CITY OF ALBUQUERQUE

September 30th, 2016

Paul Hedges: pdhedges@hotmail.com
Guardian Storage: Unser Blvd and Summer Ridge Rd

Re: Drainage Control Ordinance and NPDES CGP Violations for Erosion and Sediment Control – Guardian Storage

Inspections Plus Inc.
Erosion Control Plan
Standard Details

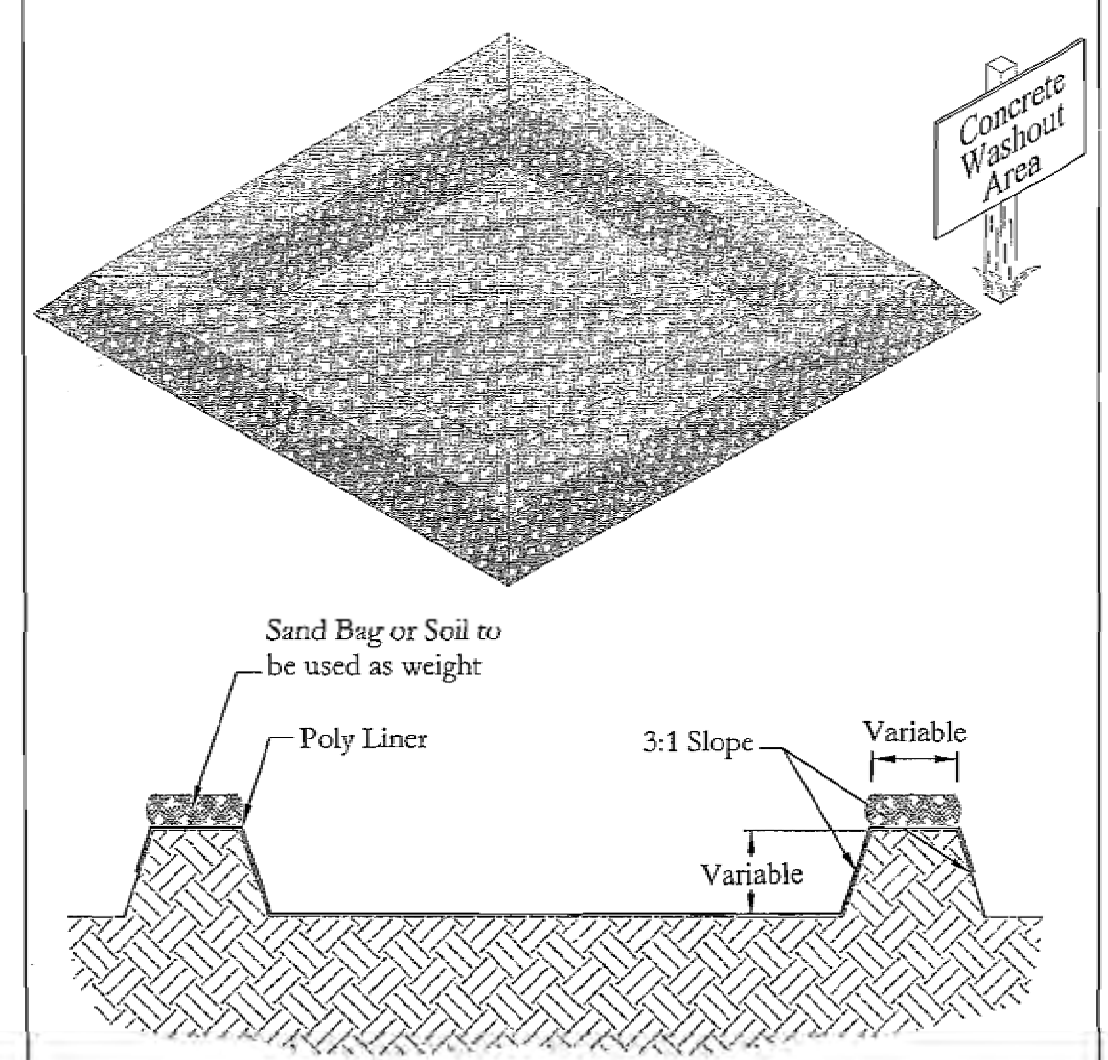
1. The construction entrance was too narrow (easy to bypass) and it did not appear to have any fabric under the rock. The rock is being pushed into the soil.

During the site inspection September 30th, 2016, the same violation was observed: entrance is too narrow and there is no fabric underneath it. The condition was not mitigated.

No change in condition of entrance. It is too narrow, does not have fabric underneath it, and it needs maintenance.

1. The stabilized entrance is to extend the entire width of the opening in the silt fence. (The entrance is very wide. It may be helpful to extend the silt fence on the north side to the south 10 feet or so.)
2. Fabric is to be placed underneath the rock. (See detail on approved ESC plan.)
3. The construction entrance is to be a continuous rock pad with no dirt area within it.
4. Pick up the trash and keep a clean site.
5. You are to obtain an approved Erosion and Sediment Control Permit.
